5 March 2015

Lismore Base Hospital – Stage 3B Redevelopment and the staged construction of a New Hospital Carpark – SSD_6848

Lismore City Council has read the Environmental Impact Statement for the abovementioned proposal and would like to make the following comments:

Figure 2 – Proposed Stage 3B Loading Access Siteworks Plan

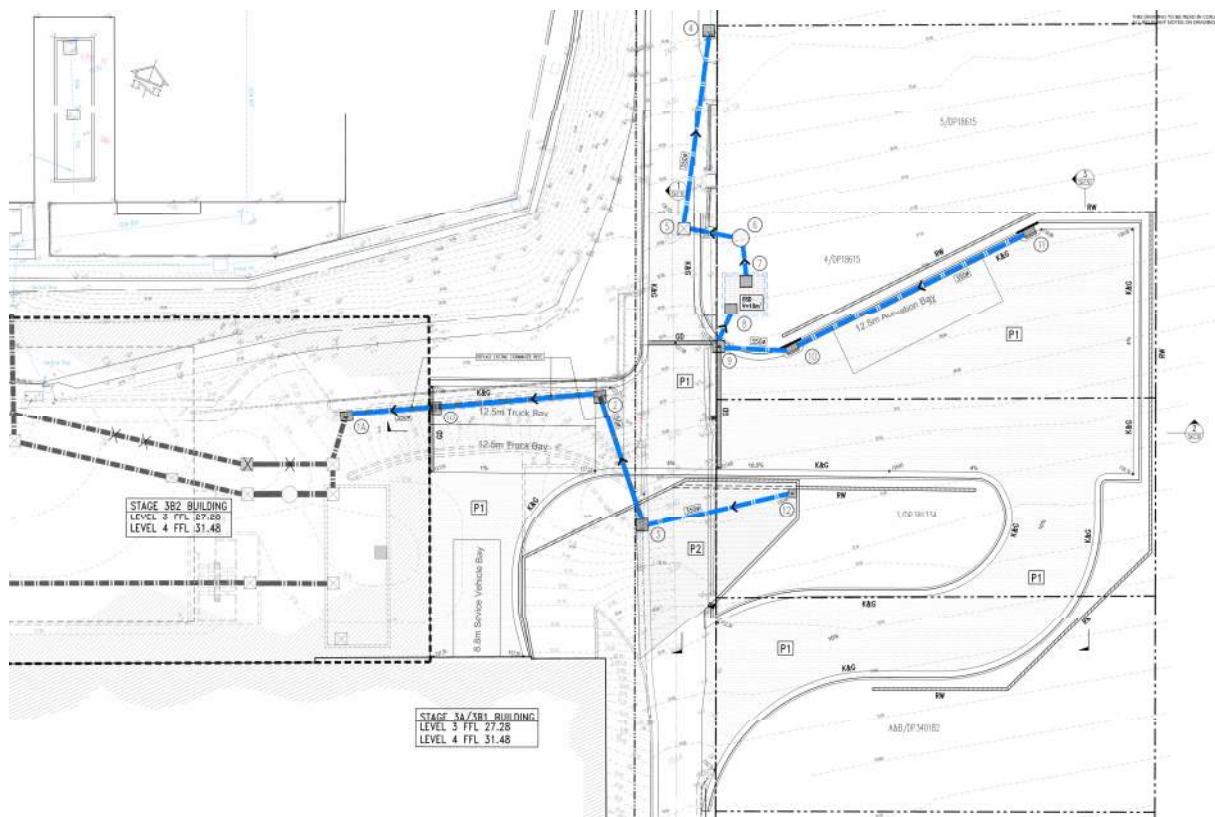
The proposed loading dock and its attendant manoeuvring areas will require the closure of the southern part of Little Uralba Street. Council is accepting of this requirement, but is concerned that in the northern part of this street there remain four residents. These residents, together with the general public, will require the construction of a 'turning area' where Little Uralba Street is closed off for hospital purposes.

The current proposal makes no provision for the orderly turning of non-hospital related traffic that may be using the northern part of Little Uralba Street. Council requires that prior to the closing of Little Uralba Street, for hospital purposes, a cul-de-sac or hammer head turning area be constructed on the public road.
